KIRKLEES METROPOLITAN COUNCIL INVESTMENT & REGENERATION SERVICE

Reference No:	2023/62/92757/W
Site Address:	2, Thistle Hill Avenue, Lascelles Hall, Huddersfield, HD5 0AX
Description:	Erection of front porch, single storey rear extension, garage extension and external render to dwelling
Recommending Officer:	Lucy Taylor

Officer Report.

Reference: 2023/92757

Garage/Games Room SW
1 : 100

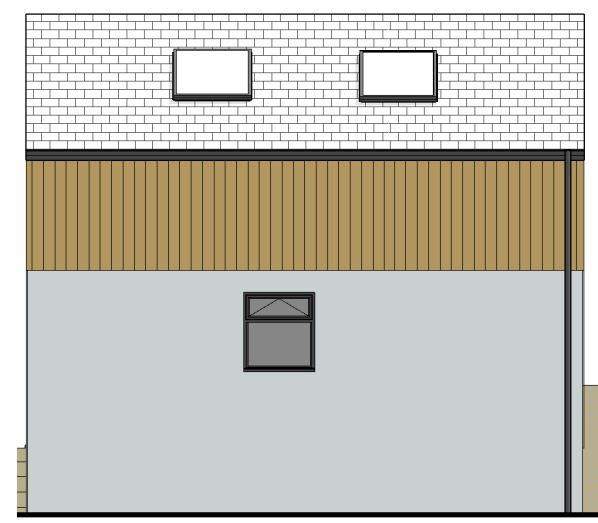
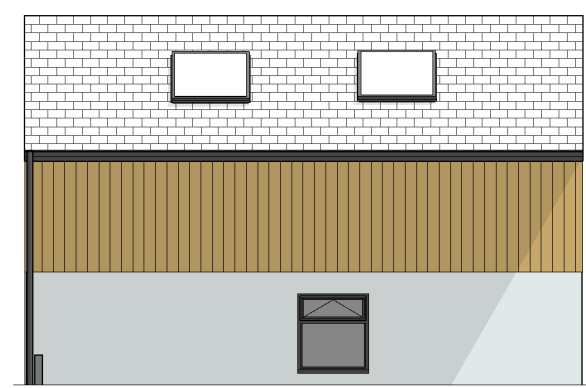
- Brick be retained to the exterior walls of the host property.
- The garage be of a smaller size/scale and be single storey, with a pitched roof with velux windows.
- The materials to face the garage be in keeping with the brick to the host property.
- The exterior materials of extensions be in keeping with the brick to the host property.

- Objection to windows, request that the velux windows to the roof of the games room are reconsidered on the grounds of privacy. If these were to go ahead as planned, they would look directly into habitable rooms at neighbouring properties.

The garage is now indicated to be a single storey structure, whilst wider and with a pitched roof. This would not reduce minimum distances between properties to this garage and it is considered to be well-separated from surroundings properties so as not to form an unacceptable feature.

It should be noted that the originally proposed games room was removed as part of the amended plan.

Gabion detail for parking area

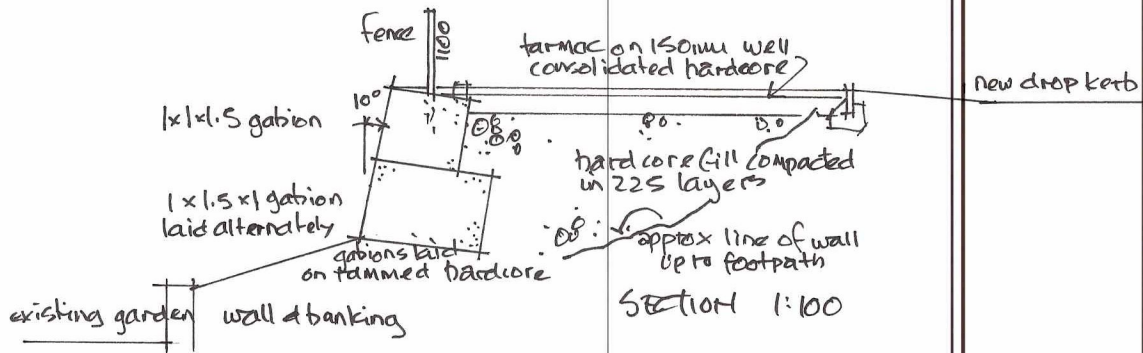
KC Highways Structures (formal & informal) – Raised no objection, with the inclusion of a pre-commencement condition regarding the submission of details for the design of the proposed retaining wall, including any modification to the existing embankment/wall supporting Lower Hall Road.

As a result of negotiation with the applicant / planning agent, an amended plan was submitted, which saw the removal of the originally proposed additional access and parking to the north east of the site. As the amendments removed the part of the proposal on the existing embankment/wall supporting Lower Hall Road, and works to an existing low retaining wall close to the boundary of the extended garage. Officers did not consider it reasonable in this instance to impose a pre-commencement condition upon any grant of approval, given the scale of amendments.
